12405 OREGON WAGON TRL
PARCEL 42170-04-028
PLAT 8096 RR-2.5 2.69 ACRES
LOT 89 THE TRAILS FIL NO 2

Date: 9/27/21 Phone: 845-541-8847 Email: jennlacoe@gmail.com Referred By: _____
Depth: 12 Roof: Tan Body: Ivory Trim: Tan # _____
Width: 40 Height: Standard Model: Carriage House Price 27,775.00

DISAPPROVED
10/18/2021 7:37:10 AM
michaela
CONSTRUCTION

Width: 40 Height: Standard Model: Carriage House Price 27,775.00

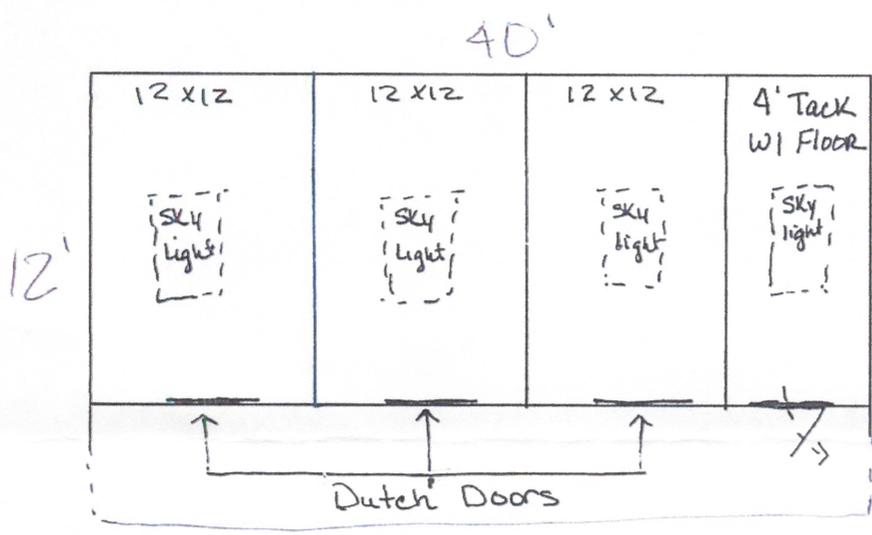
Provide engineer stamped plans for the metal building. A design professional stamped soils report and foundation design must be provided to the building inspector at the first inspection.
